Addendum No. 1

RE: Contract ID C203755

New Hanover County (W-5103A)

US-421 From Bridge #30 To North Of George Anderson Avenue

PROJECT REFERENCE NO. W-5103A	SHEET NO. 23
RW SHEET NO.	
ROADWAY DESIGN ENGINEER	HYDRAULICS ENGINEER
8/24/2015 1:20 PM PT	8/24/2015 5:52 PM ET

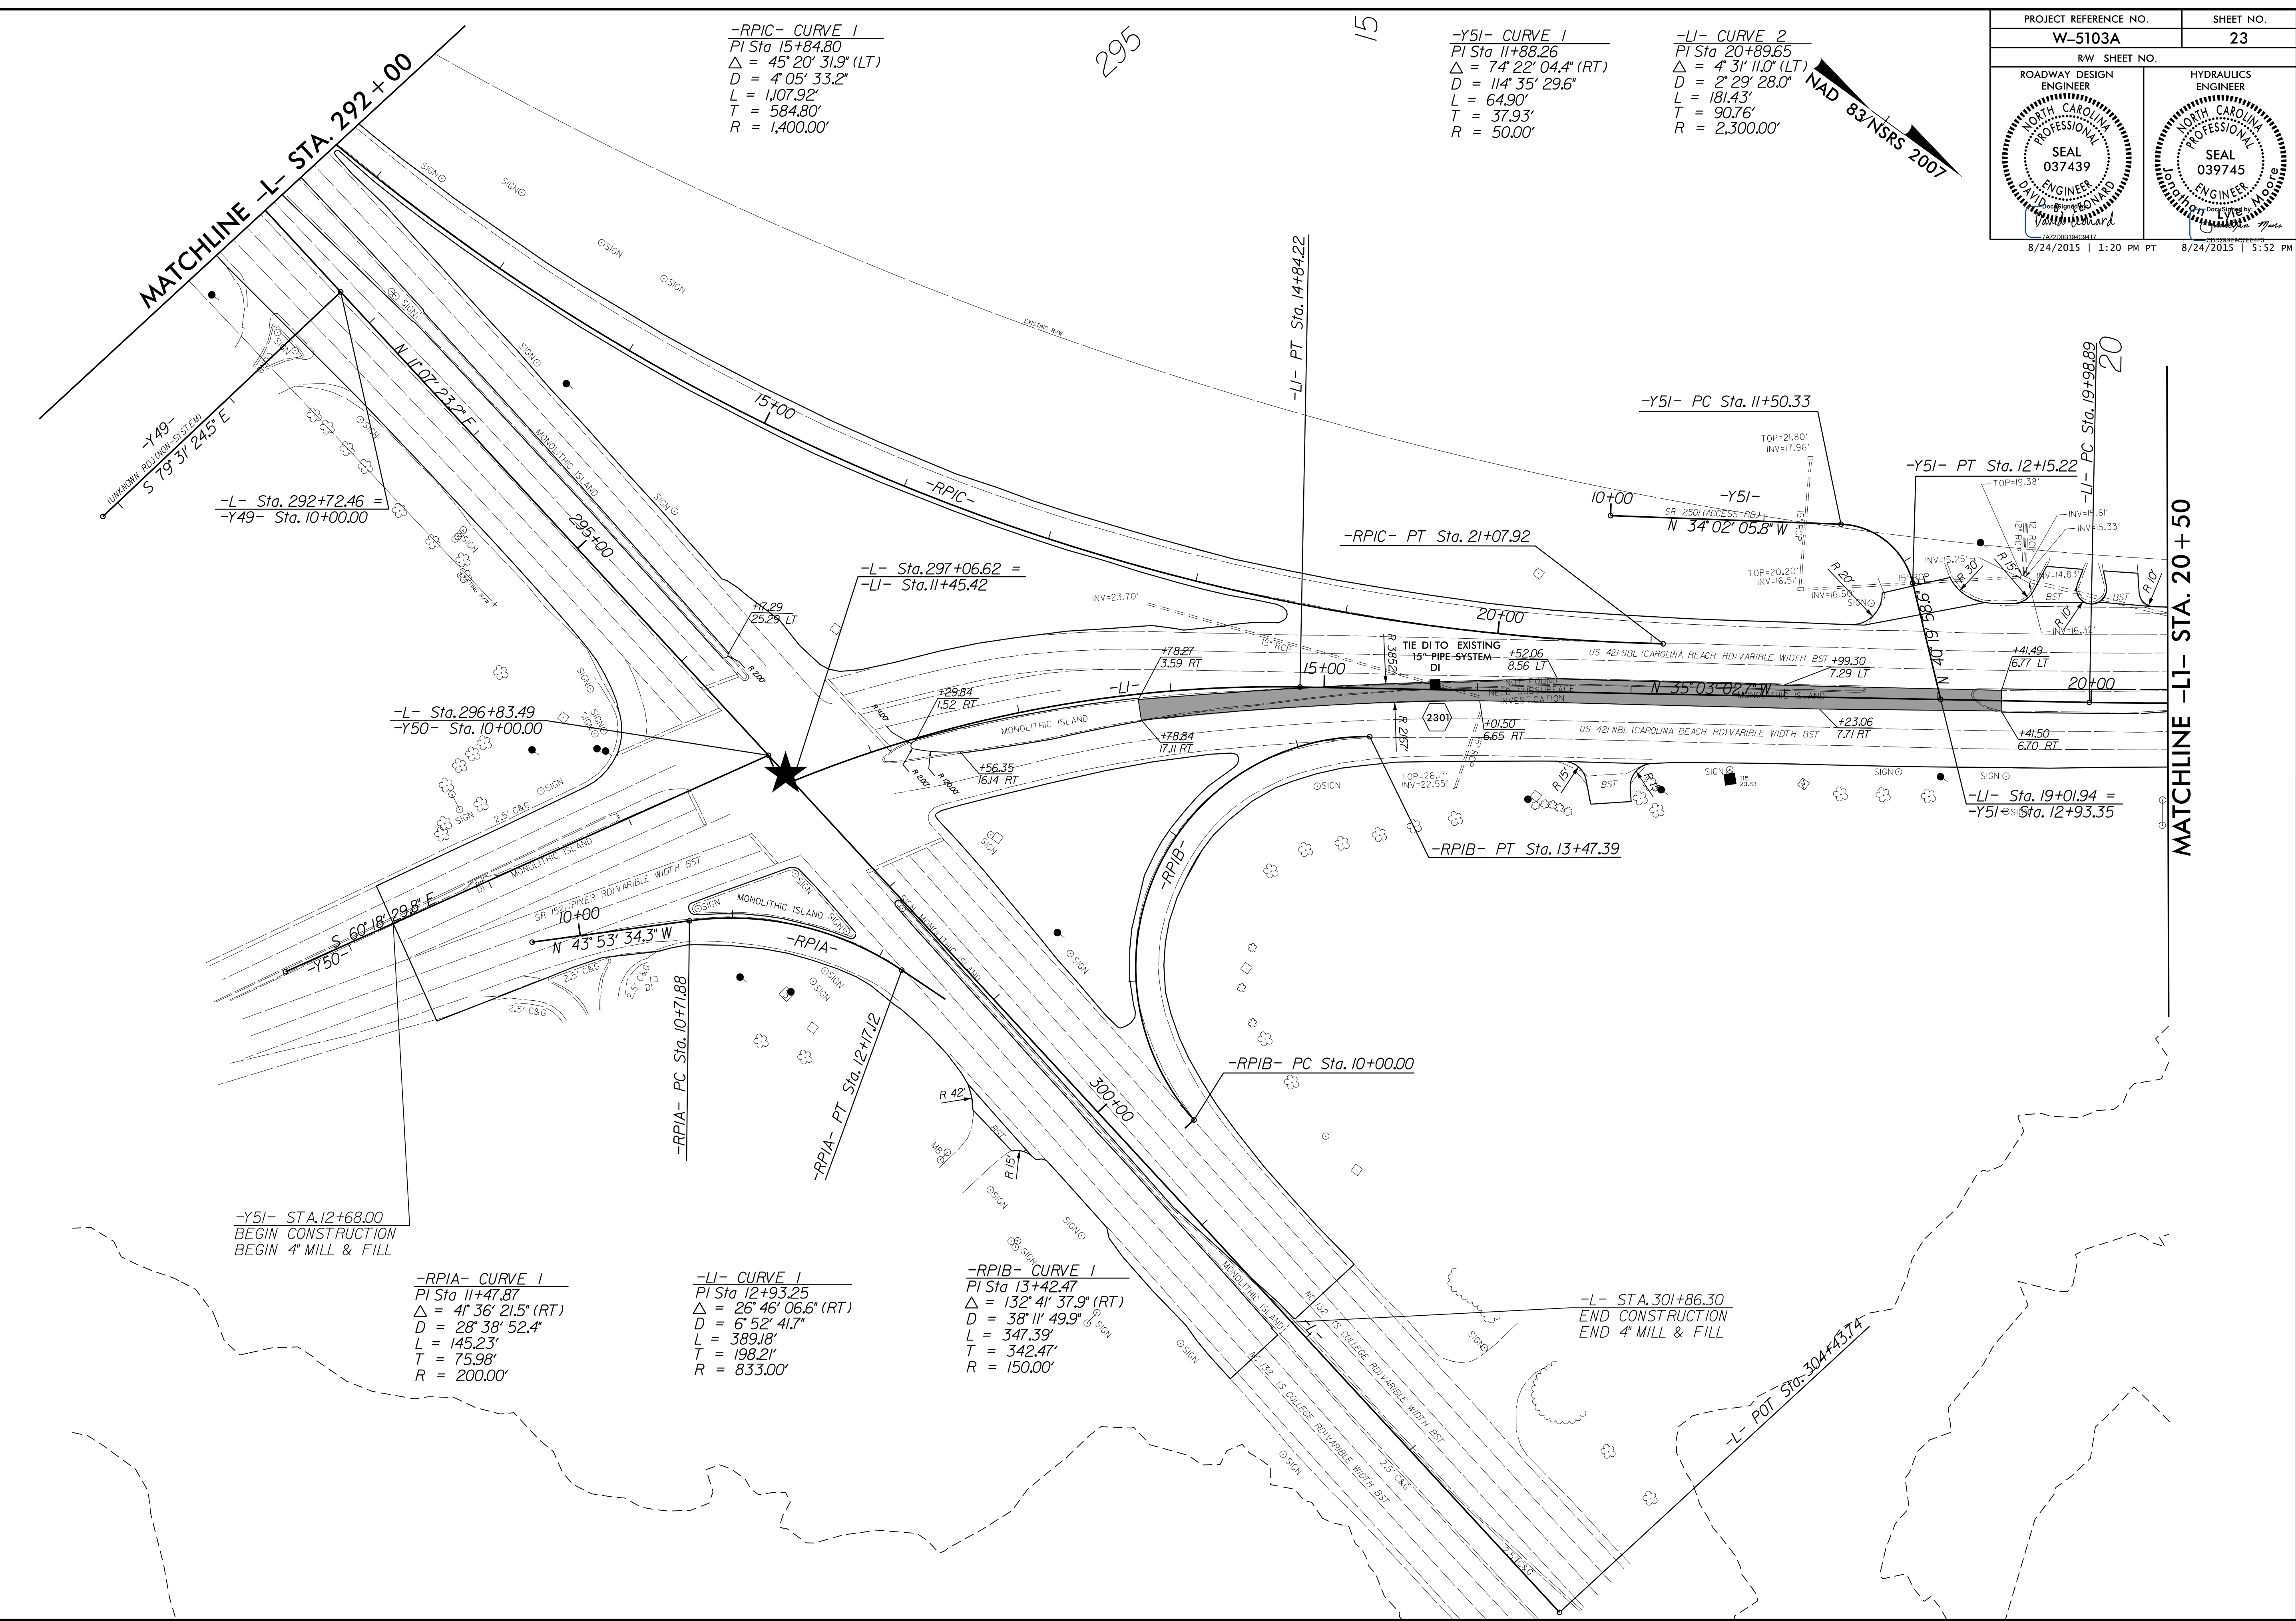
Sheet No.	Revisions
3D-6	Revise drainage summary to reflect the below noted drainage quantity changes
23	Added drainage Str. # 2301
